28 January 2018

Alexandria Park Community School Redevelopment, Park Road, Alexandria (SSD 8373) submission

AR.DA. 5002

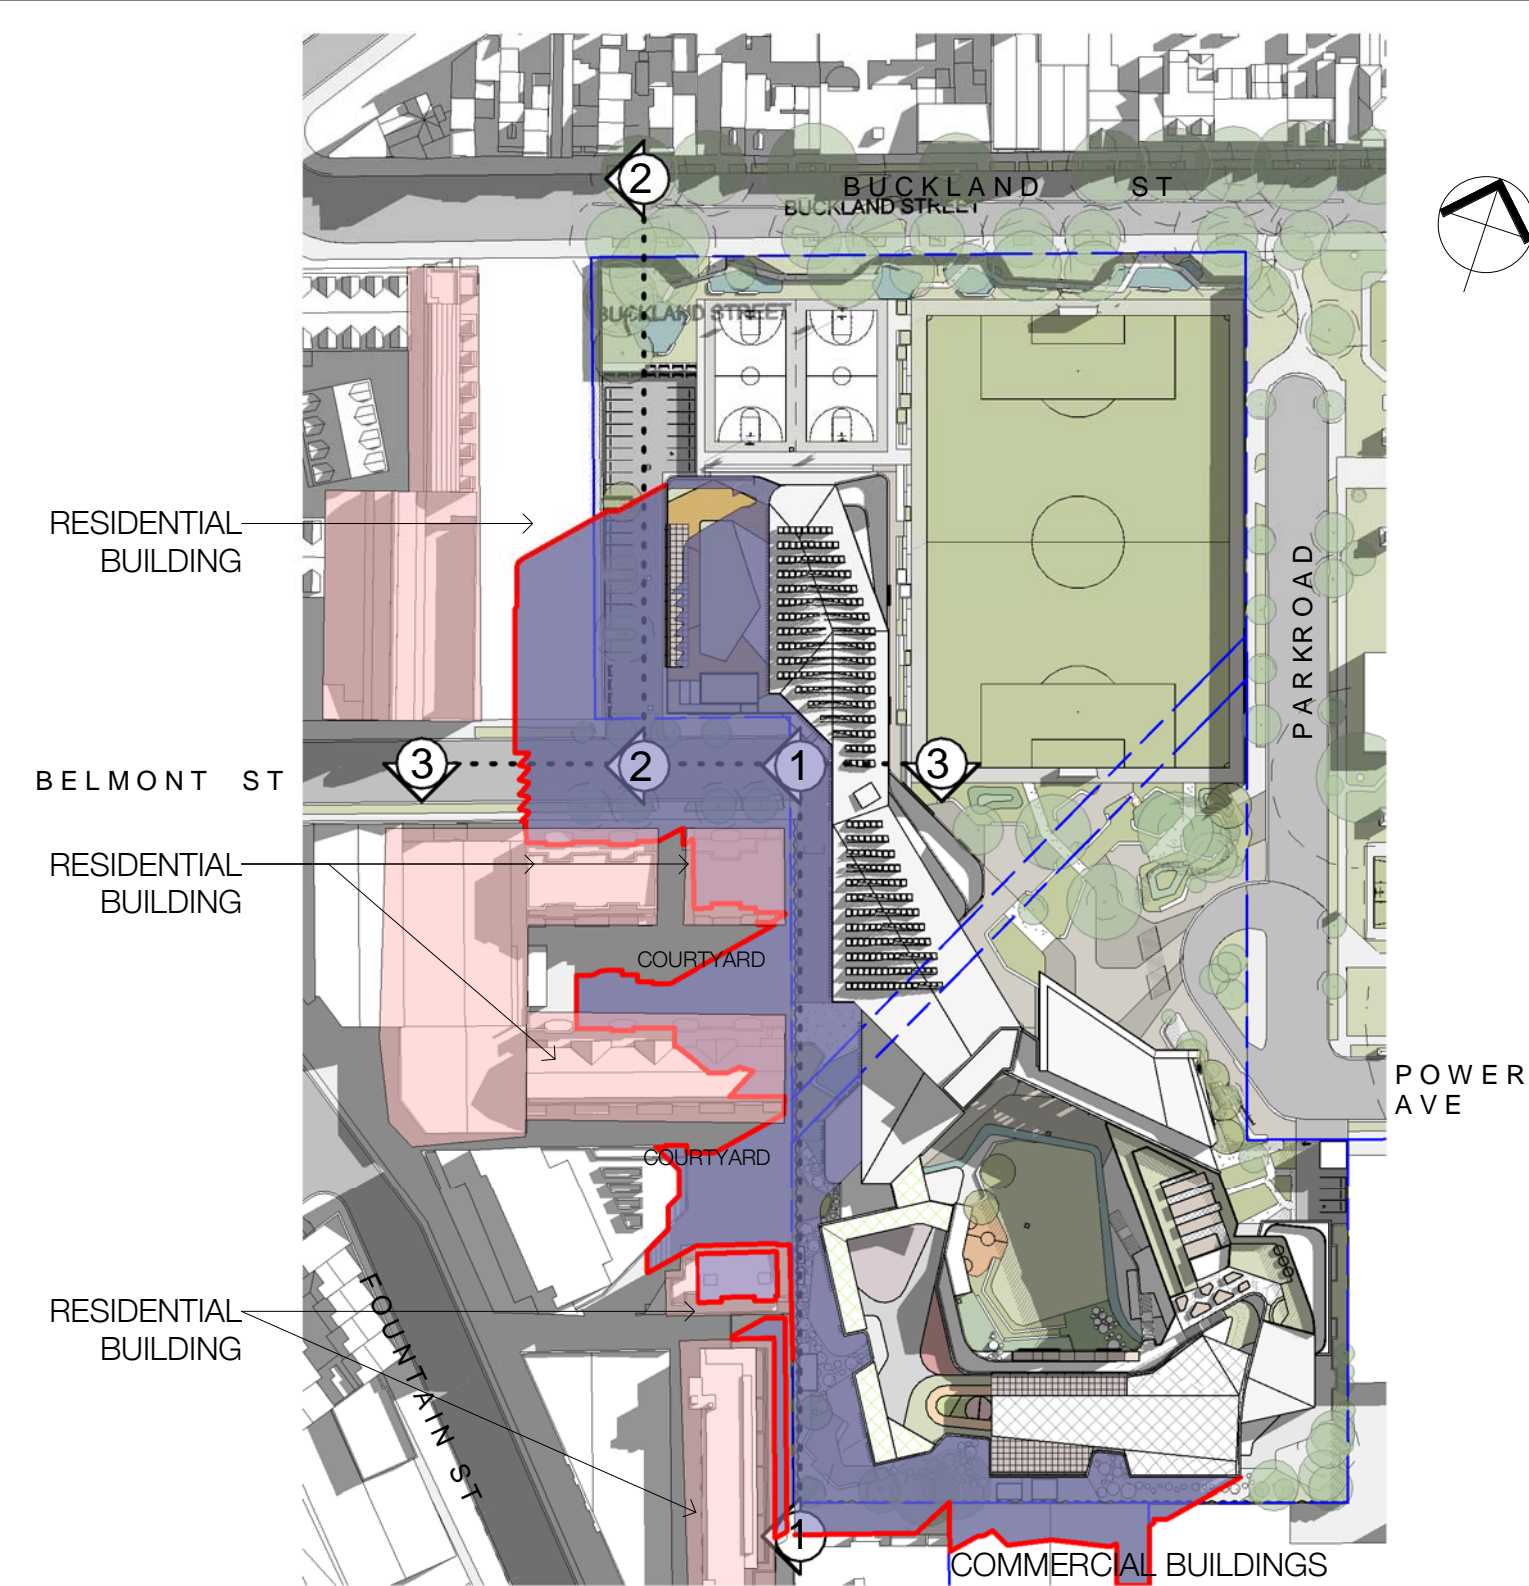
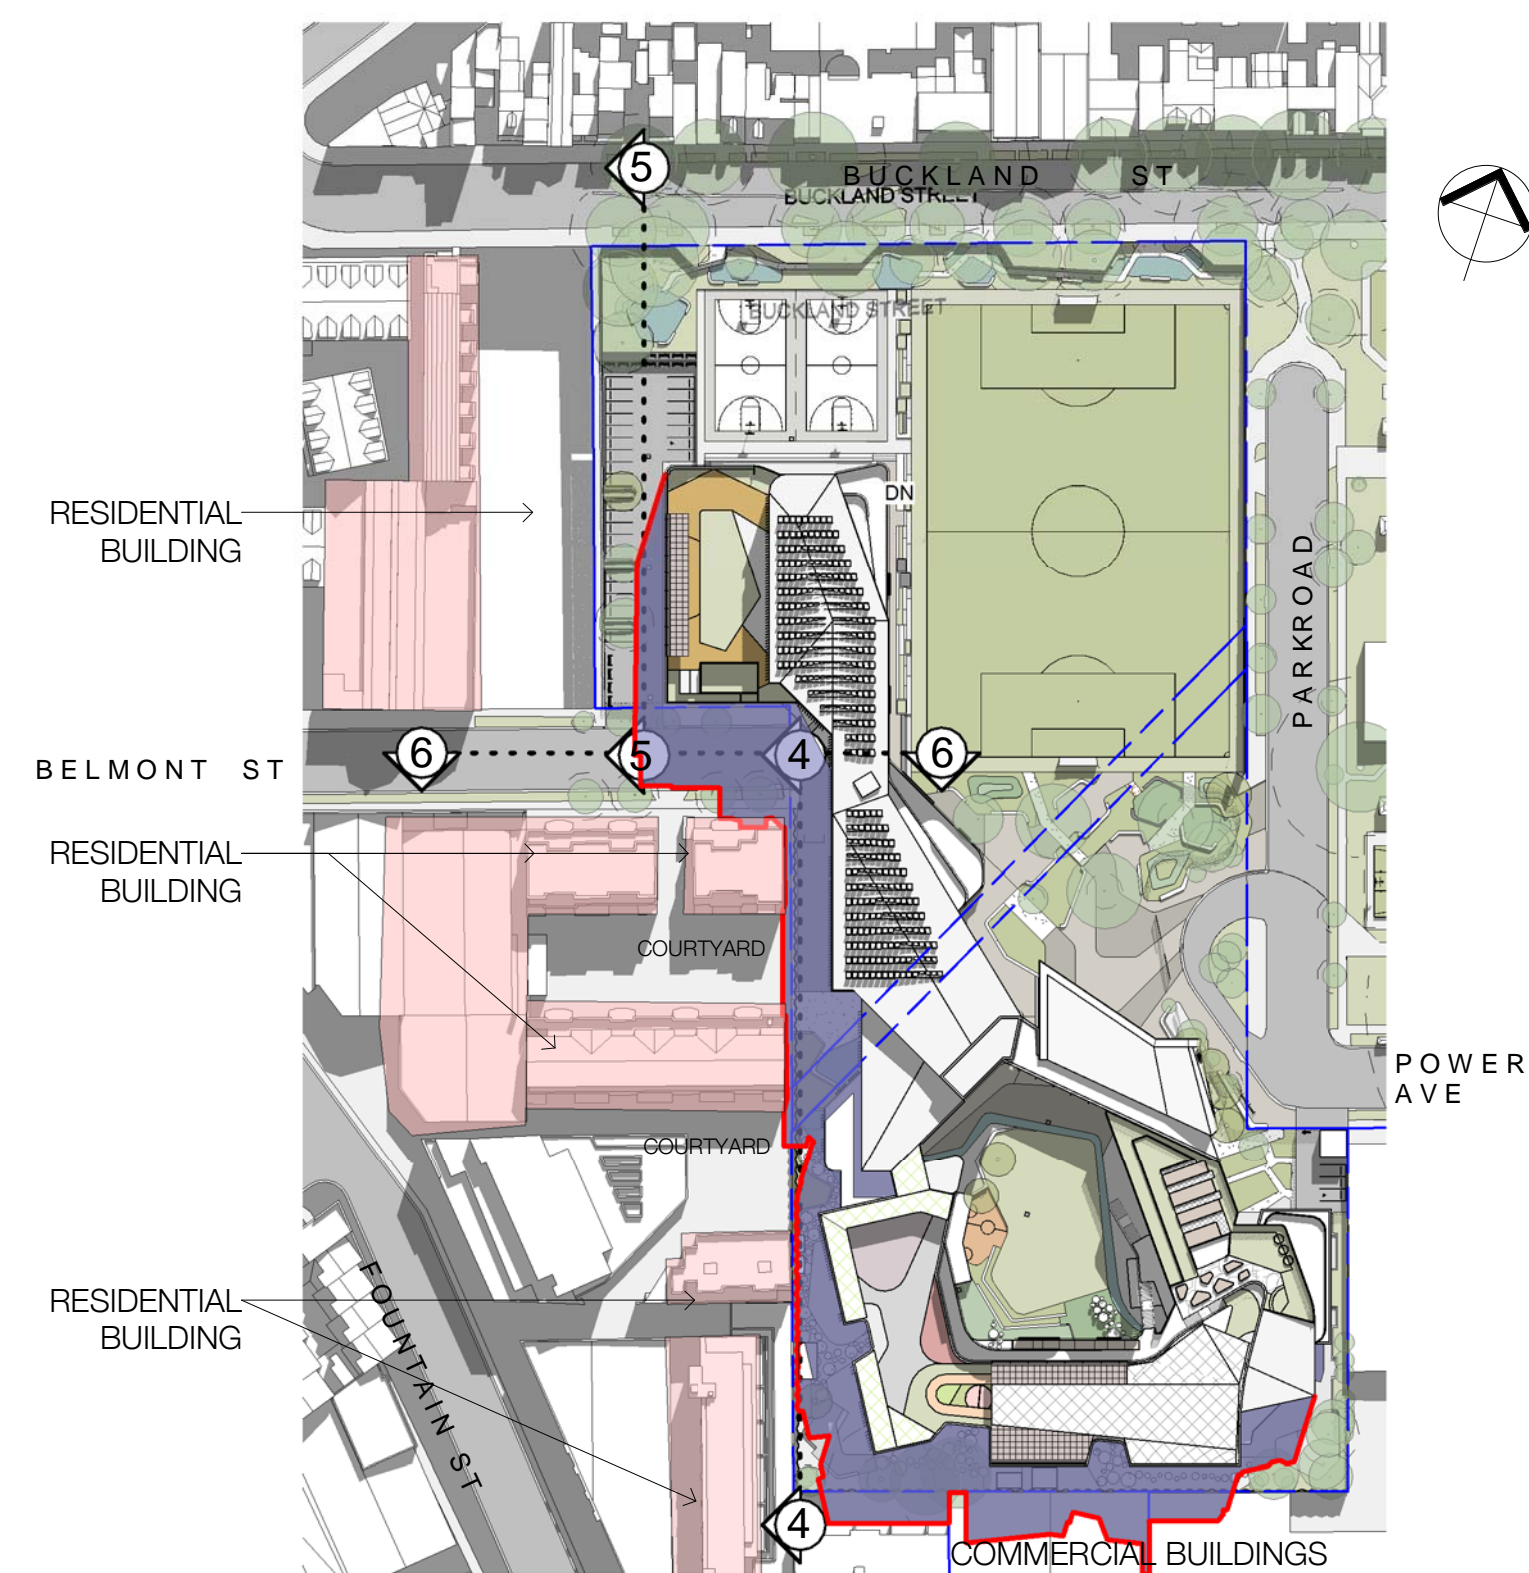
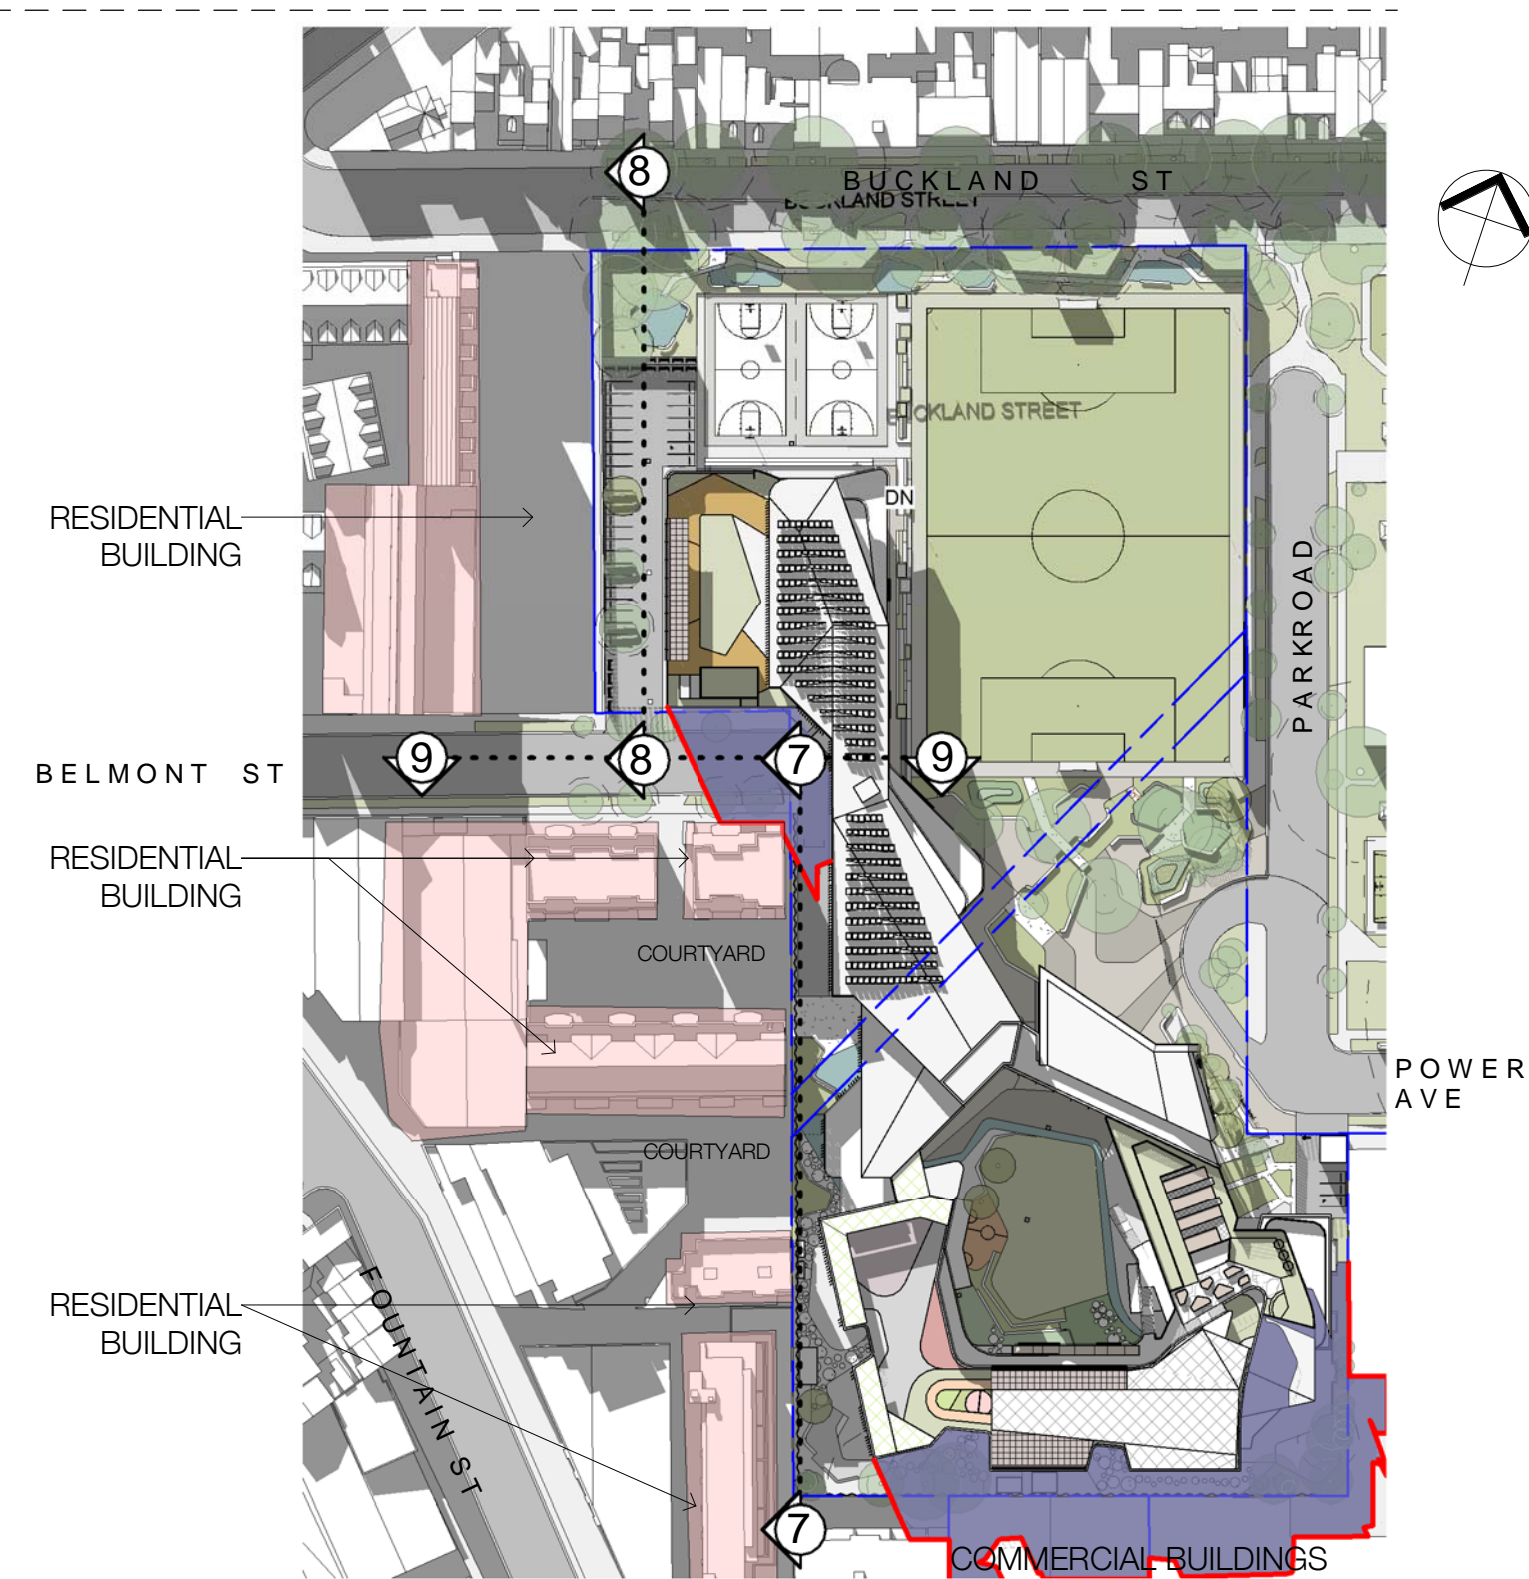
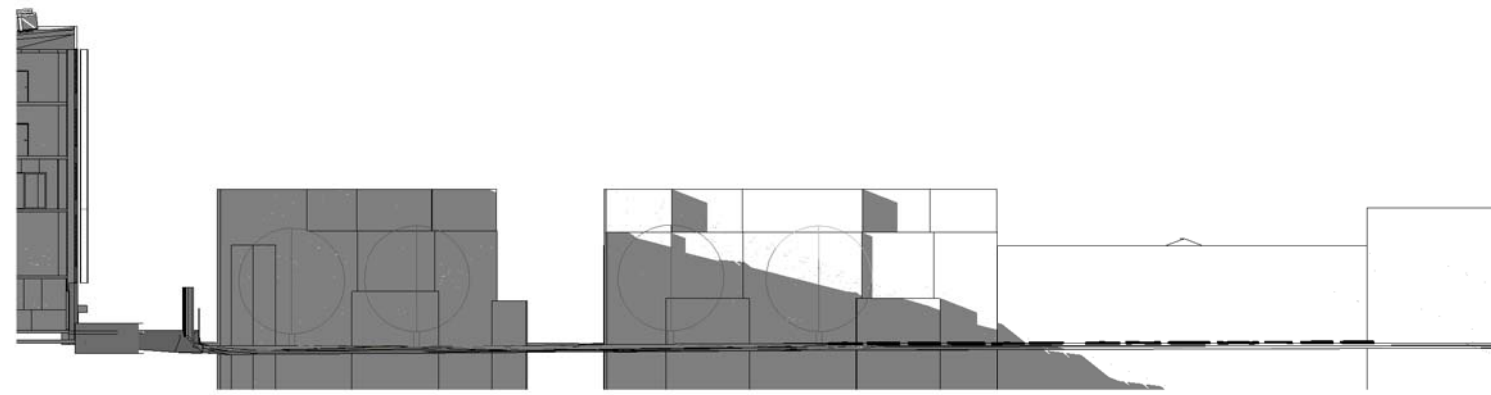
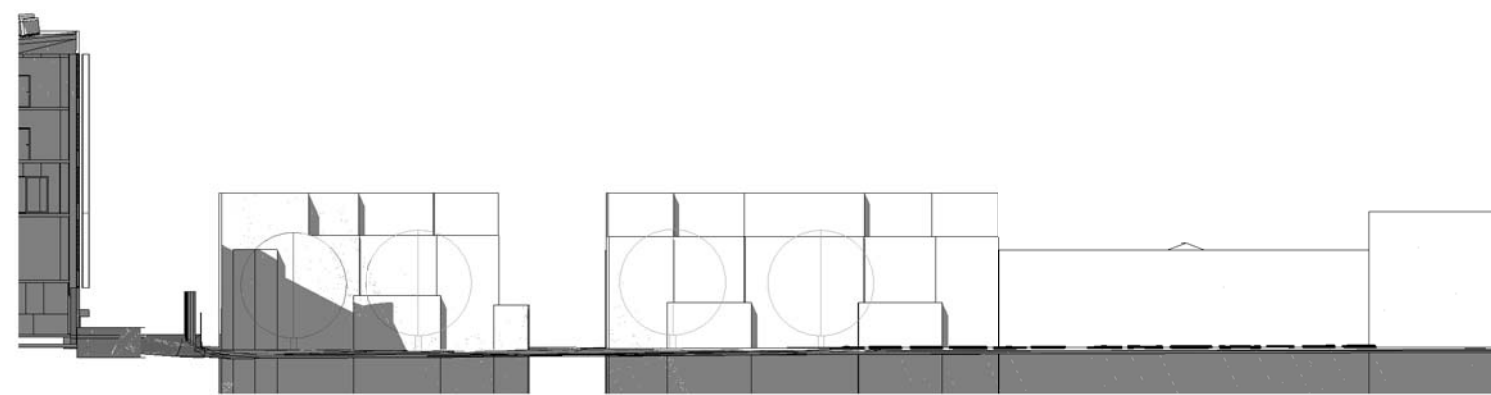
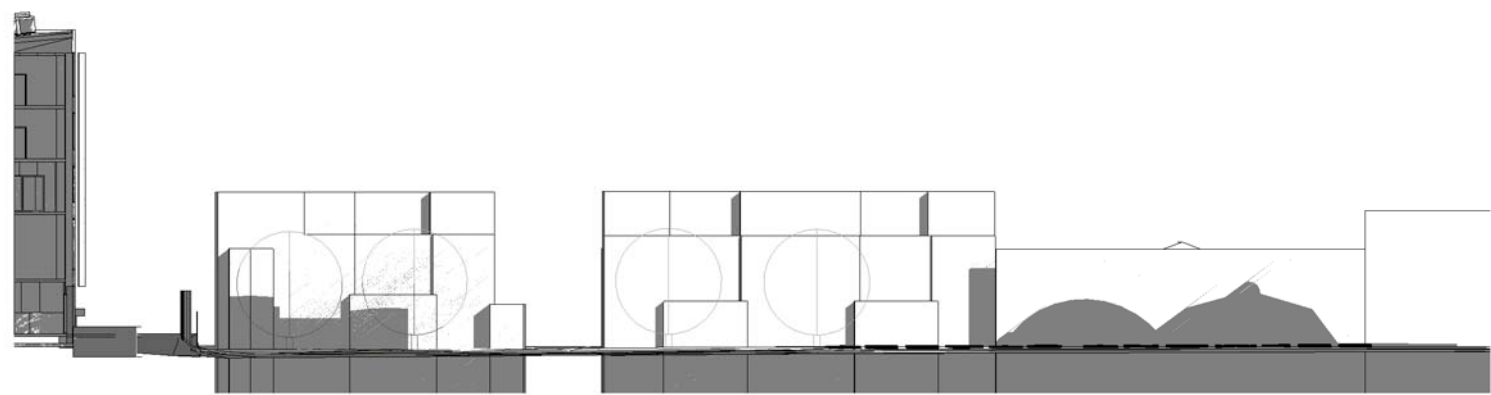
We are extremely concerned at the solar overshadowing the proposed 5 storey, 21 metre building will cause to our ground floor garden apartment Lot 10 of 44-58 Belmont Street, on the Western side of the school. From the shadow diagrams provided, our primary living area, dining room kitchen and front garden courtyard will lose approximately 50% or 4 hours of full sun light on the winter equinox from sunrise at 7.00am until approximately 11.00am. Our apartment again will lose sun due to overshadowing by existing buildings to the north of our apartment sometime mid afternoon. It is unclear how many hours of direct solar access we will have left if the proposed school building is built. Due to the design of our apartment, having only two points of solar access, a front sliding door facing north and a back door facing south, with no other windows on either the east or west of the apartment, we are heavily reliant on good solar access for light and warmth and wellbeing from these points. If hourly solar overshadowing diagrams could be provided as required they would assist to clarify the extent of overshadowing.

We respectfully suggest that consideration be given to exploring opportunities to reduce the extent of solar overshadowing on neighbouring residences on the western boundary of the school. A combination of the following may be considered:

- Reducing the height of buildings which will overshadow neighbours on the western boundary to the current 15 m height limit for this site;
- Terracing the western facing upper floors back from the western boundary; and/or
- Moving buildings on the western boundary further away from neighbouring residences.
